Consultation Response from KC,
Lead Local Flood Authority

2025/92160 Grange Moor Coachworks, Barnsley Road, Grange Moor, Huddersfield, WF4 4DR

Discharge of details reserved by Conditions 24 (Surface Water Strategy), 25 (Exceedance), 26 (Temp Surface Water), 27 (Interceptor), 29 (Sewer Easement), 30 (Foul Water), 31 (Archaeological Investigation), 34 (Road Condition Survey), 35 (CTMP), 40 (Retaining Walls), 41 (Travel Plan) on previous permission 2023/90668 for demolition of existing buildings; erection and operation of single building comprising Sui Generis land use limited to the purpose of storage, assembly, sale and distribution of custom-built computers, laptops and their components as well as any associated development (those being a replacement wind turbine, utility provision, drainage, access, hard and soft landscaping) within the red-line boundary alongside business operations pursuant to the effective administration of the Sui Generis use

Discharge of Drainage Conditions

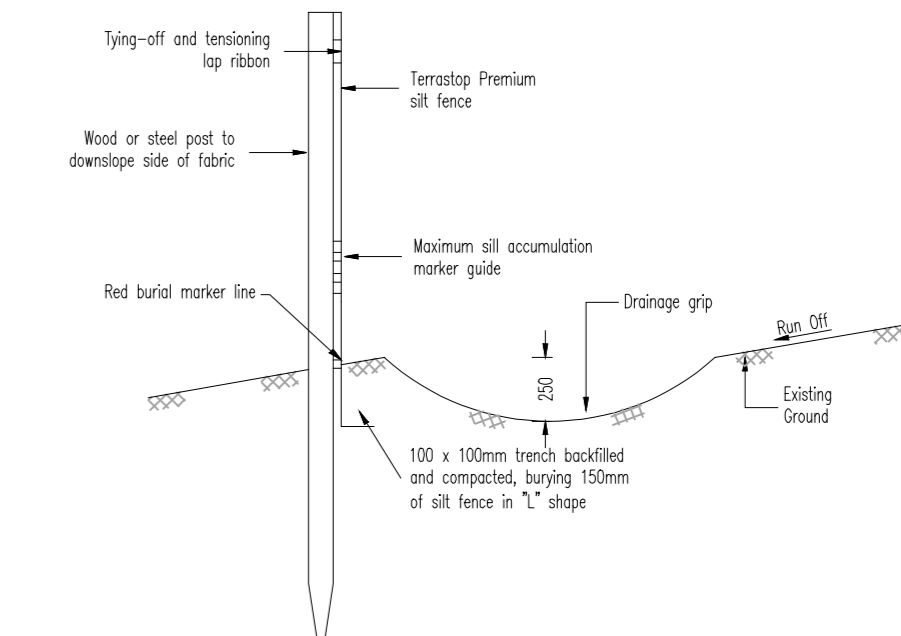
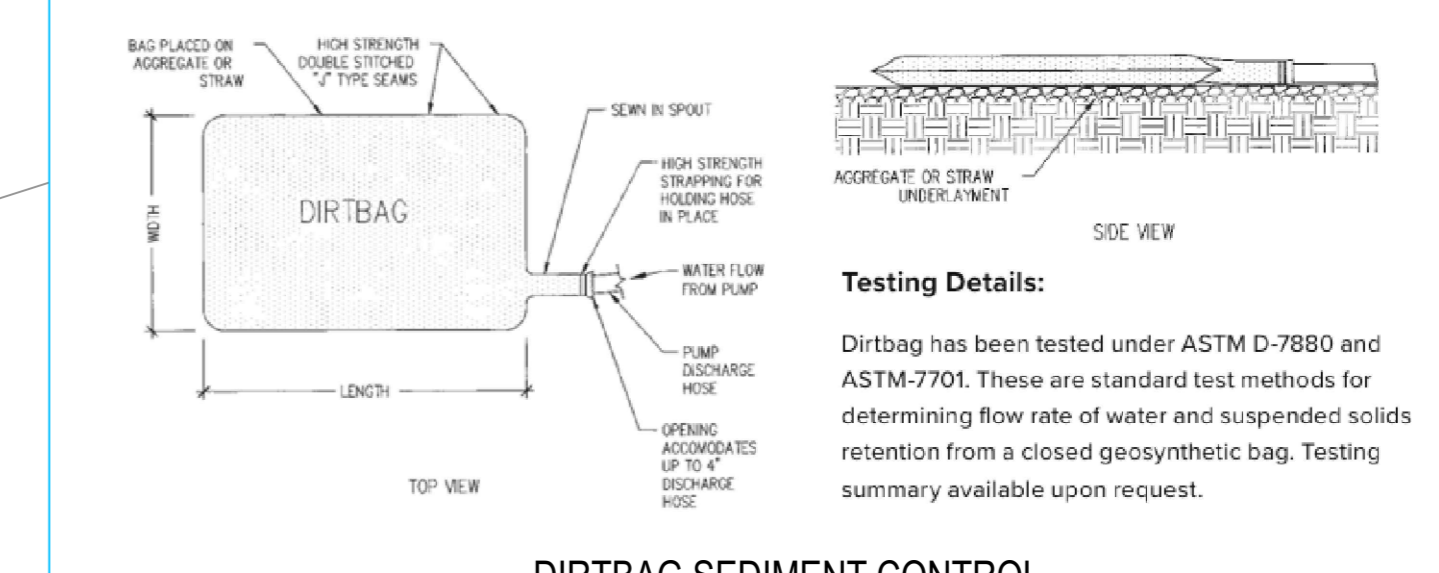
The LLFA confirms that the Temporary Surface Water Management Plan is acceptable. Therefore, Condition 26 **can be** discharged.

Client	ACUMEN
Project	PC SPECIALIST GRANGE MOOR
File	Proposed External Works
Drawn	STP
Checked	SAB
Date	April 2025
Scale	1:250
Original by/for	AO
Drawing Number	P3849-DR-02
Rev	P01

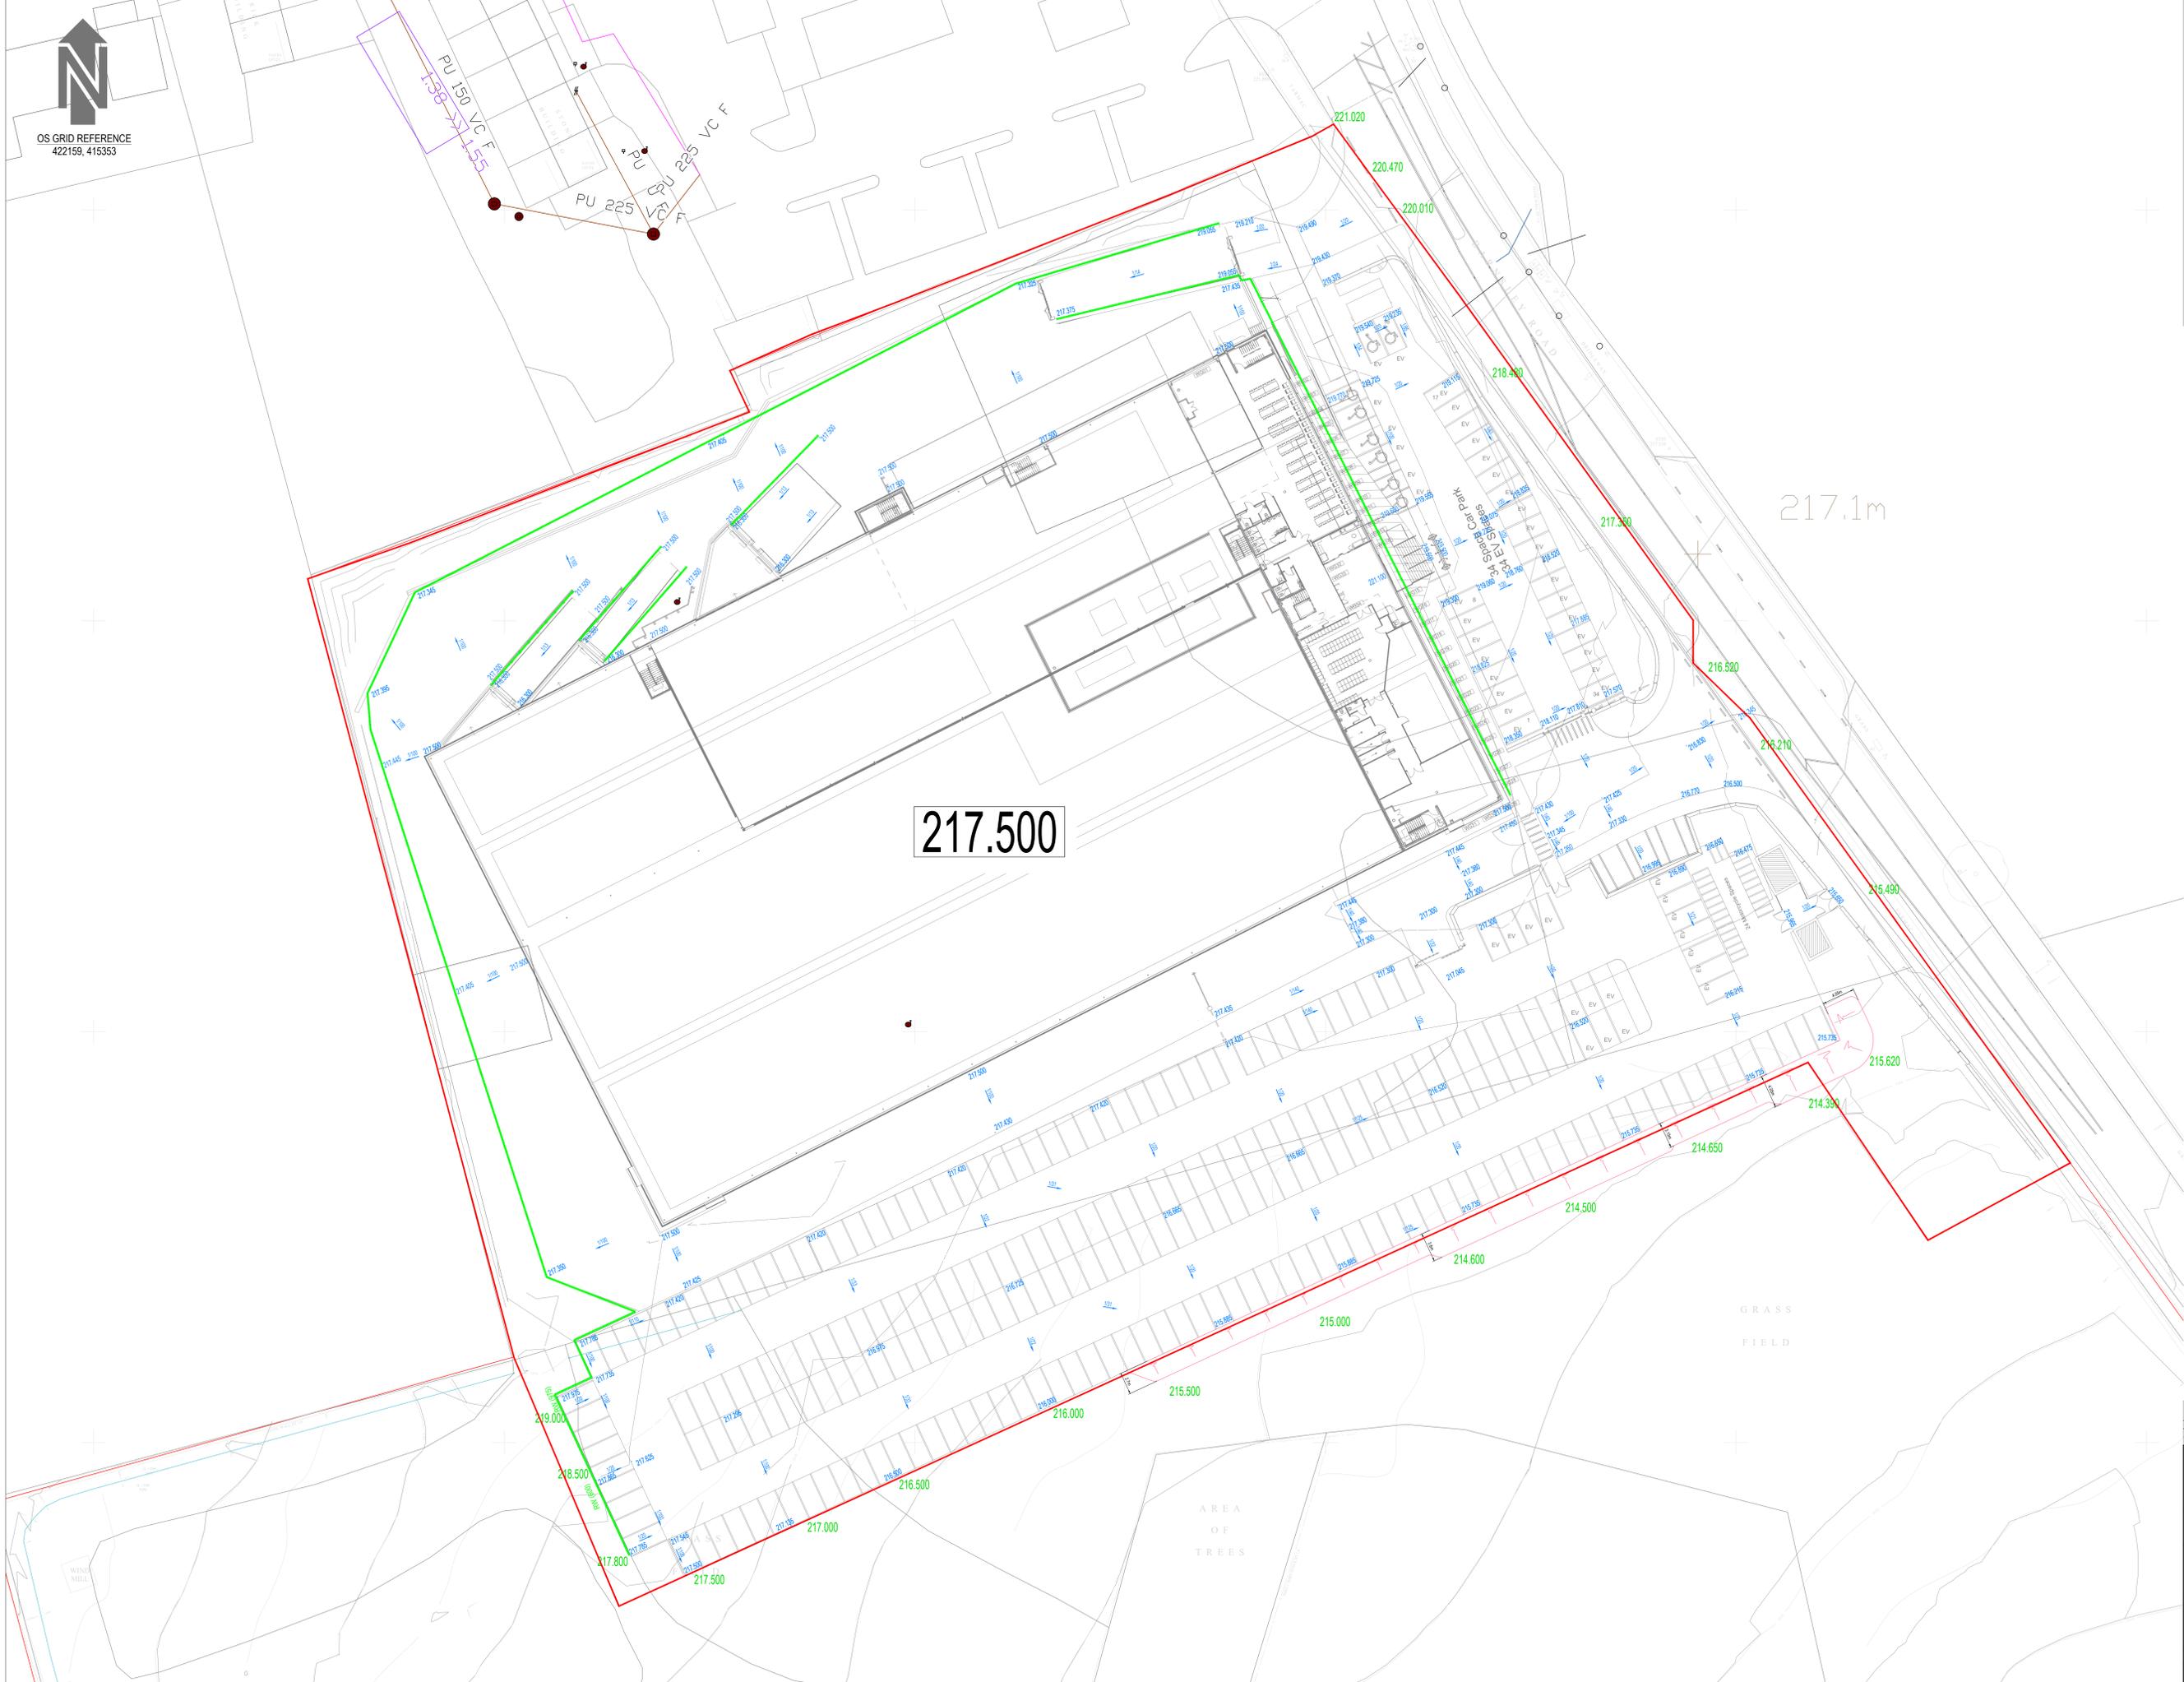
The LLFA confirms acceptance of the proposed allowable discharge rate of 32.7l/s, outfalling into the existing pond. However, no hydraulic calculations have been provided to confirm that the proposed surface water attenuation volume is sufficient for the design rainfall event. Therefore, Condition 24 **cannot be** discharged.

The LLFA confirms that the Oil Separator details on the Proposed Drainage Strategy Plan are acceptable. Therefore, Condition 27 **can be** discharged.
